## Tarago and District Progress Association Inc.

### **Modification Request to Woodlawn Bioreactor site (MP\_100012 MOD1 and DA Q91/00233 MOD2)**

Figure 3.3 - Annual windroses for Goulburn Airport 5 years and 2015 only

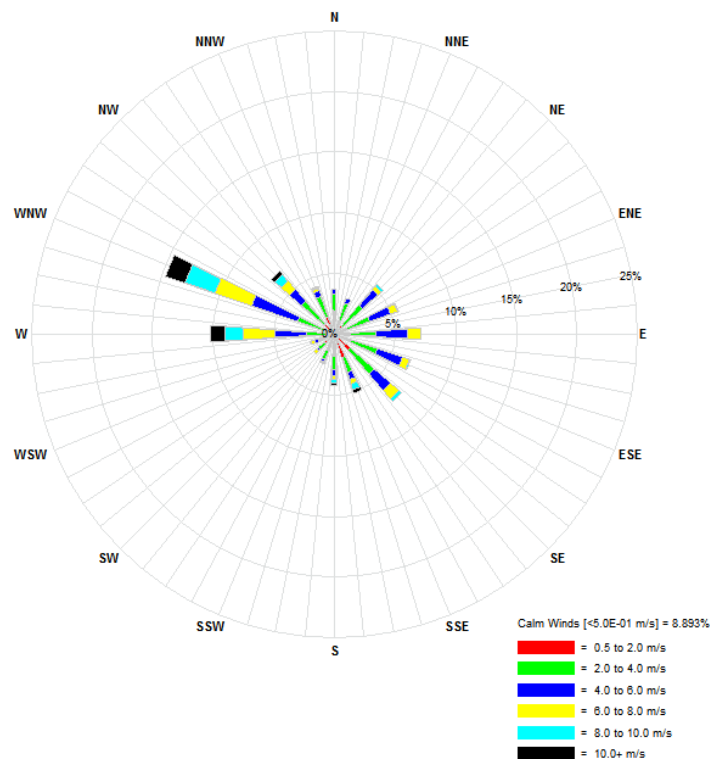
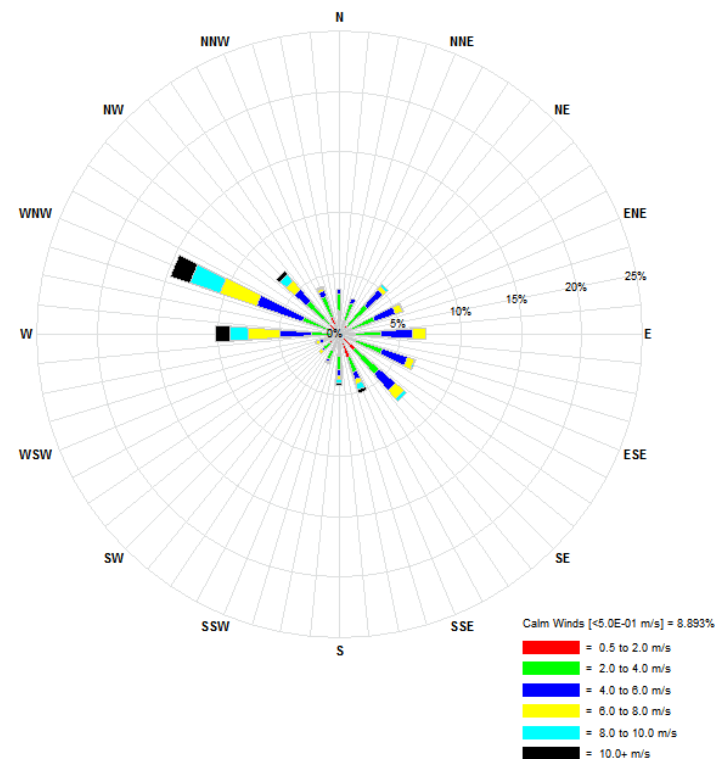
- Figure 3.3 appears to show the same chart twice, rather than 2 charts showing Windroses Goulburn Airport 5 years and 2015.
- The receptor mentioned on page 24 as being north of the Bioreactor doesn't appear to be marked on any of the images in figures 4.1 through 4.5
- The email address on page 2 is misspelled.
-
